**RE: Primrose School at 4550 Paradise Blvd NW
Erosion and Sediment Control Plan - C13E029
Engineer's Stamp Date (6/5/25) SWQ-2025-00034**

Per the correspondence June 18, 2025, please find the following responses addressing the comments listed below:

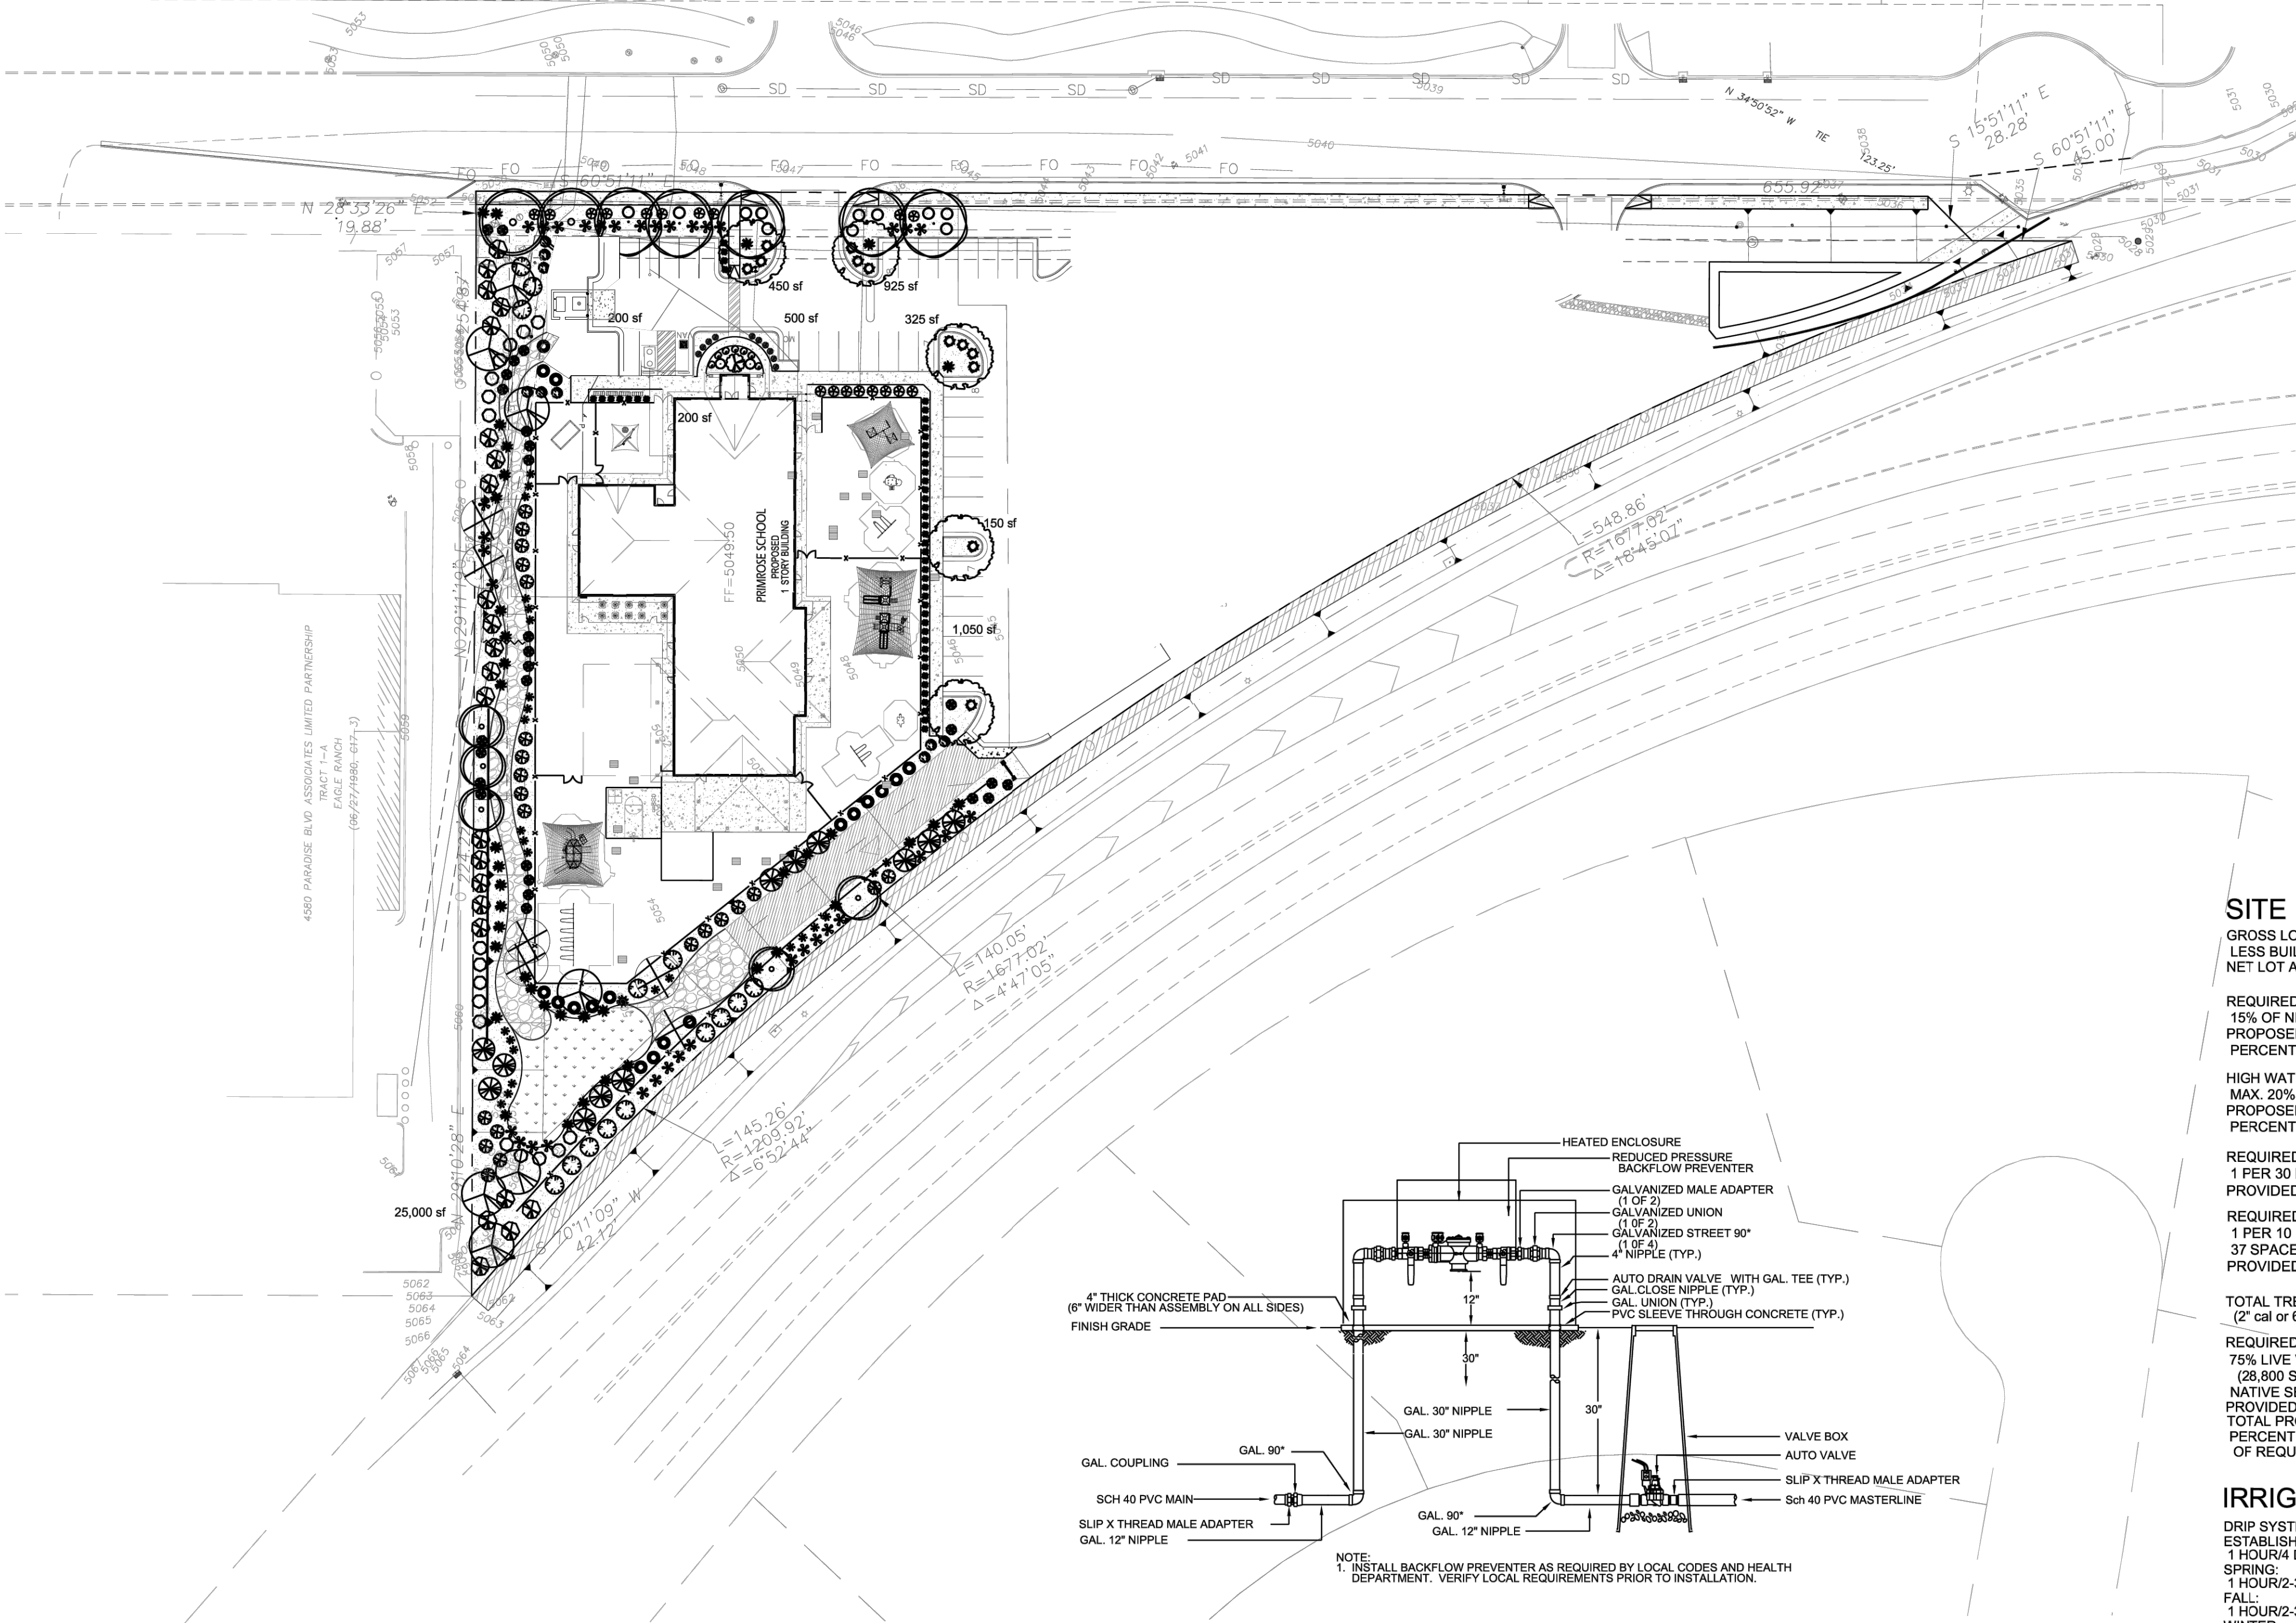
4. The SWPPP must include site-specific interim and permanent stabilization per CGP 9.6.1.c.i. The Landscape Plan and Work Order sheets can be used to satisfy this requirement and should be submitted separate from the ESC Plan with the
